Morecambe Offshore Windfarm Generation Assets

The following constitutes Natural England's formal statutory response for Examination Deadline 6.

Boundary reduction to avoid potential effects on Shell Flat

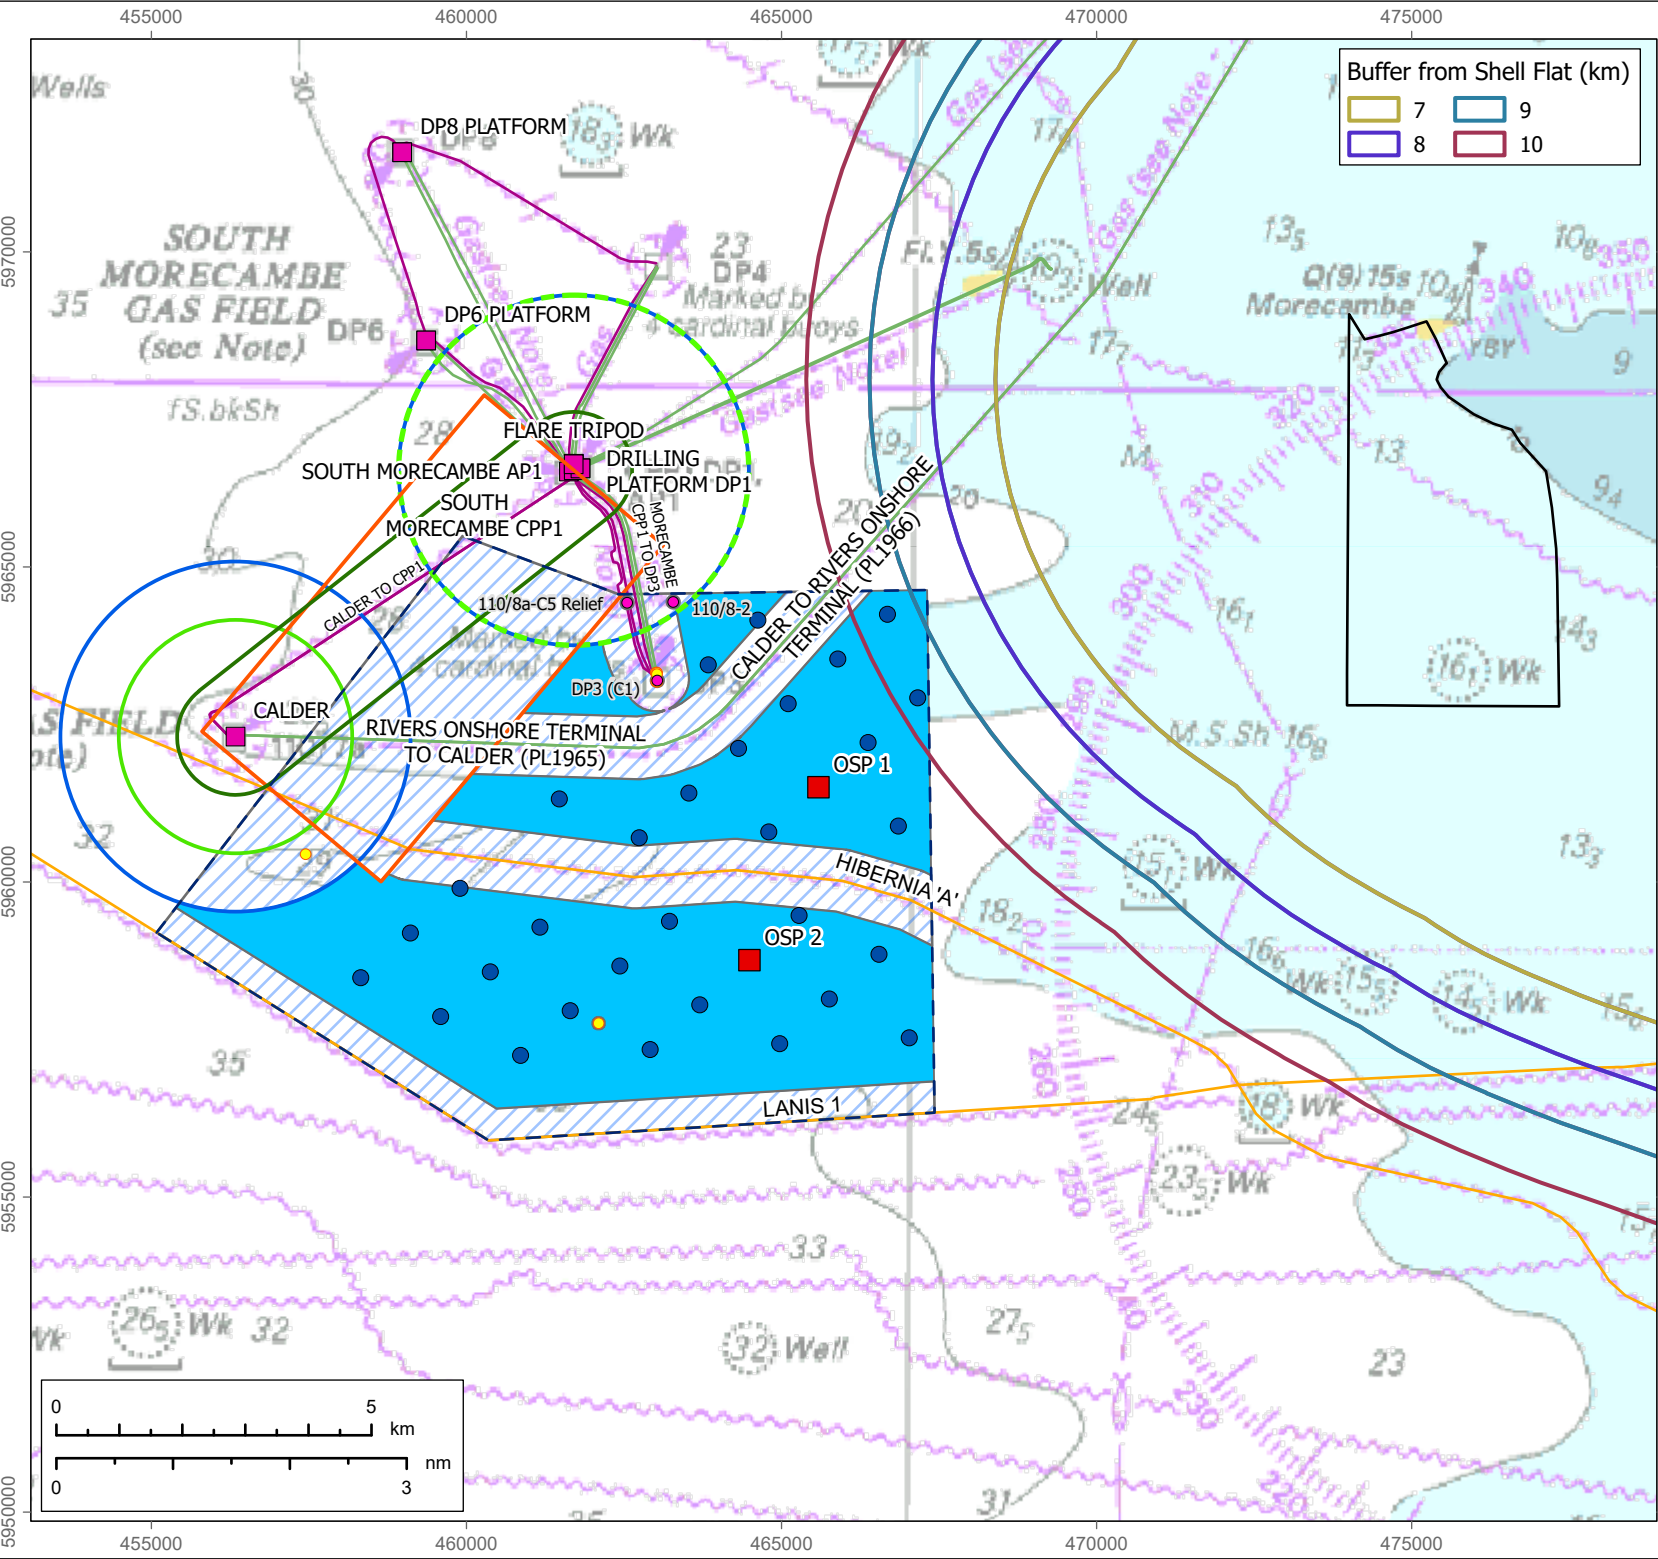
Natural England's outstanding concern regarding the red-throated diver feature of Liverpool Bay SPA is the mitigation of impacts. Until the Applicant's submission of its response to ExQ 3GEN2 and 3GEN3 at Deadline 5a [REP5a-057] there had been no submission into Examination of assessments of displacement impacts to red-throated diver under different mitigation scenarios i.e., implementing various buffer distances between the turbine array and the SPA. Of the scenarios presented, the most conservative in terms of reductions to the Project site under which AEOI in-combination could be ruled out is the 10km Shell Flat buffer scenario. This buffer would reduce disturbance to what is likely to be the key area of habitat for RTD within this part of the SPA, given the shallower water depths there. The SPA 8km buffer would cover the whole area included in the Shell Flat 10km buffer, with the additional benefit of reducing disturbance to a larger proportion of the original SPA boundary.

AEOI could also be ruled out under the 7.5km SPA buffer scenario, which includes the majority of the Shell Flat 10km buffer. Under the notional turbine layout scenarios presented by the Applicant, this would result in the removal of the same WTG locations from the envelope, and thus the same reduction in disturbance for the Shell Flat area as the 10km Shell Flat scenario. However, we do note that other turbine layouts could still place a WTG inside the Shell Flat 10km buffer under this scenario and therefore result in some level of displacement within the Shell Flat area, and were the consent to be based on this scenario it would be appropriate to have a commitment to avoiding this. As with the 8km SPA buffer, the 7.5km SPA buffer would also provide the added benefit of reducing potential displacement effects to a larger proportion of the original SPA boundary.
